**From:** Mundy, Ben - Oxfordshire County Council <Ben.Mundy@Oxfordshire.gov.uk>  
**Sent:** 25 September 2023 11:25  
**To:** DC Support; Lewis Knox  
**Cc:** Transport CDC Minor; Cllr George Reynolds  
**Subject:** 23/02368/F Longview, Pound Lane, Sibford Gower, Oxfordshire, OX15 5AE

**Planning Application:** 23/02368/F

**Location:** Longview, Pound Lane, Sibford Gower, Oxfordshire, OX15 5AE

**Description:** Demolition of existing dwelling and erection of replacement dwelling and outbuildings

**DRAWING TITLE:**  
Existing vs Proposed Development

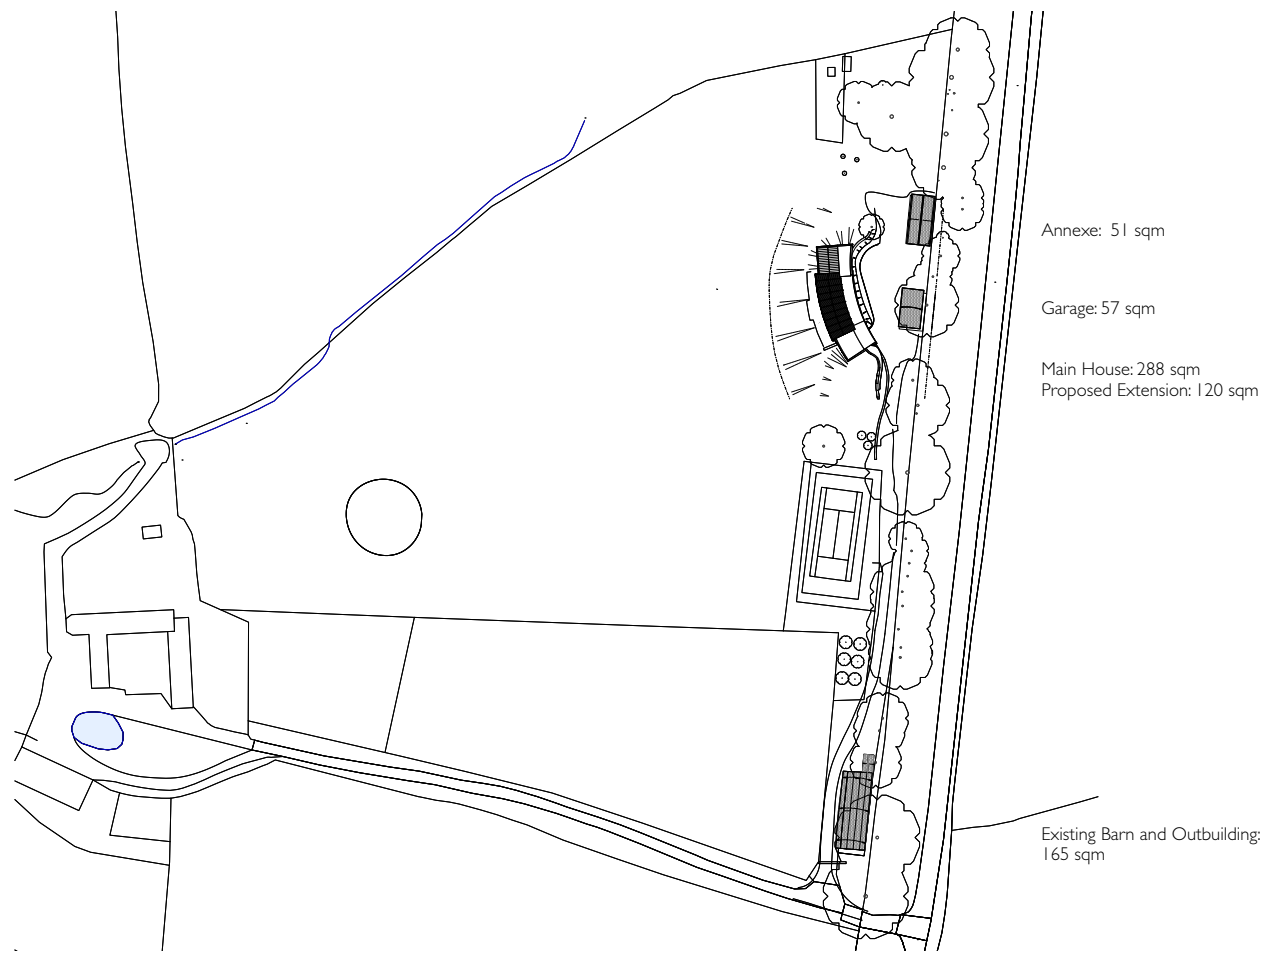
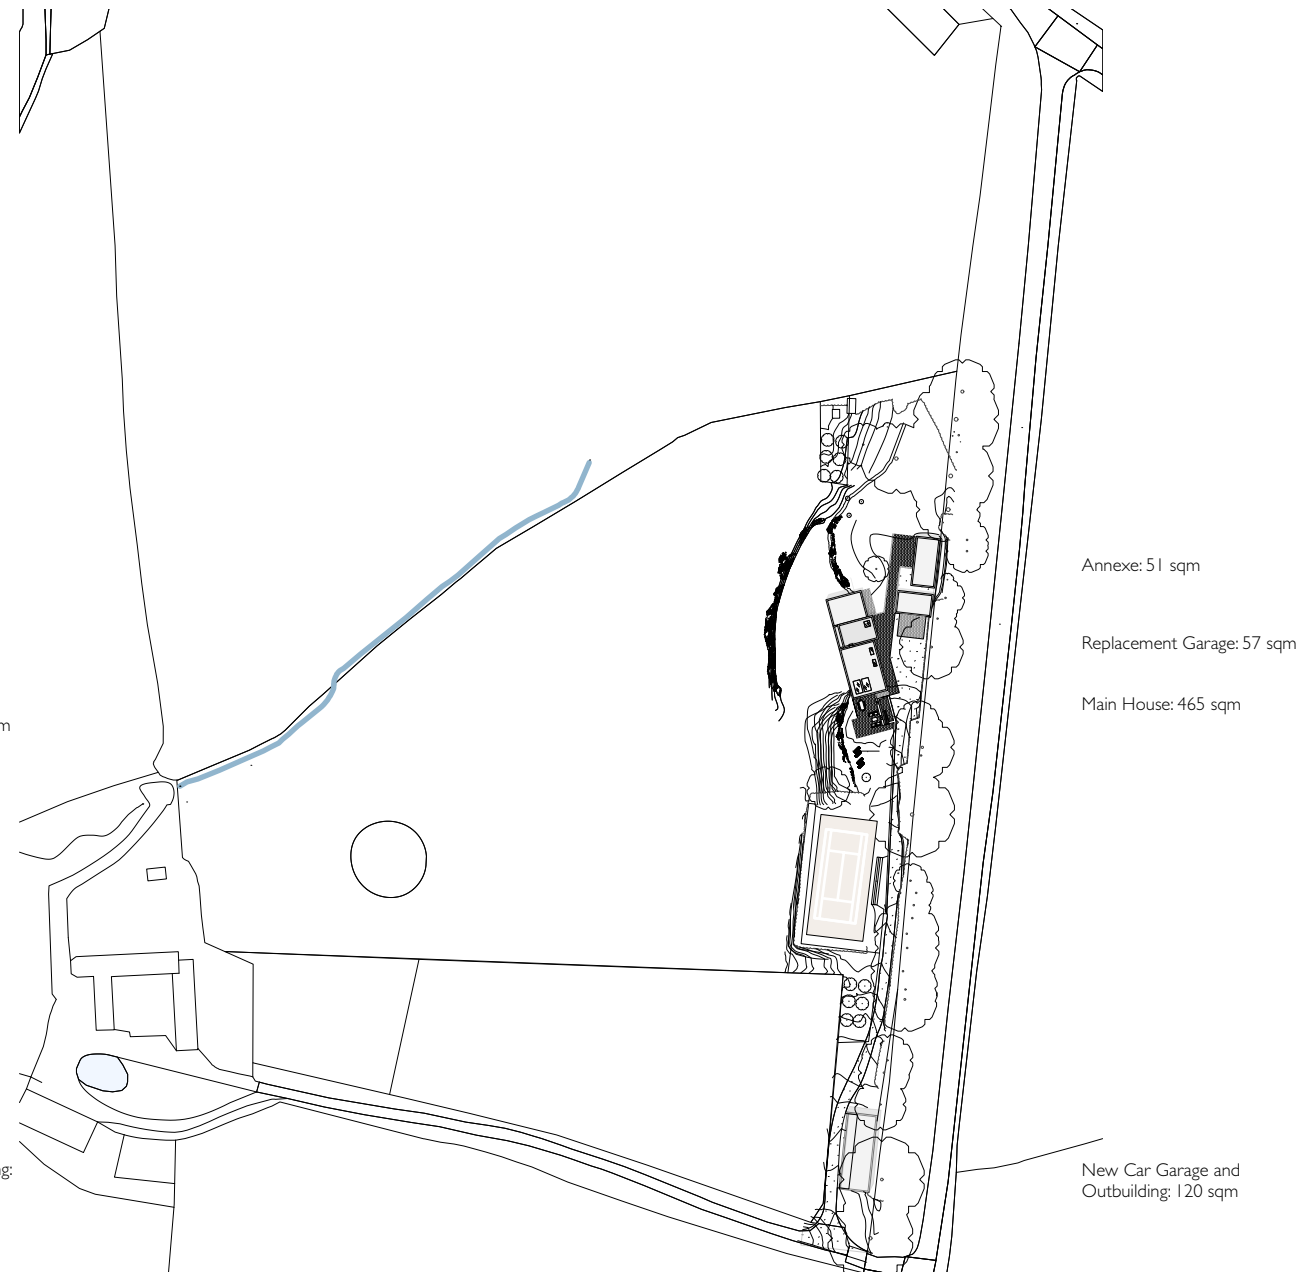
As this dwelling is a replacement dwelling, the access arrangements are unchanged. The vehicle movements from the site are not likely to increase significantly as a result of the proposed development, therefore it poses a minimal risk to highway safety.

The proposal outlines new garages for both the main dwelling and an annexe to provide up to 4 vehicle spaces. As the proposal makes use of existing land, that is likely to be used for parking, it cannot be seemed to be significantly increase vehicle parking on site and therefore is acceptable in this circumstance. The garages and outbuildings can also be used for cycle parking.

Prior to the first occupation of the development, a scheme for the provision of a vehicular electric charging point to serve the development shall be submitted to and approved in writing by the Local Planning Authority. The vehicular electric charging points shall be provided in accordance with the approved details prior to the first occupation of the unit they serve, and retained as such thereafter.
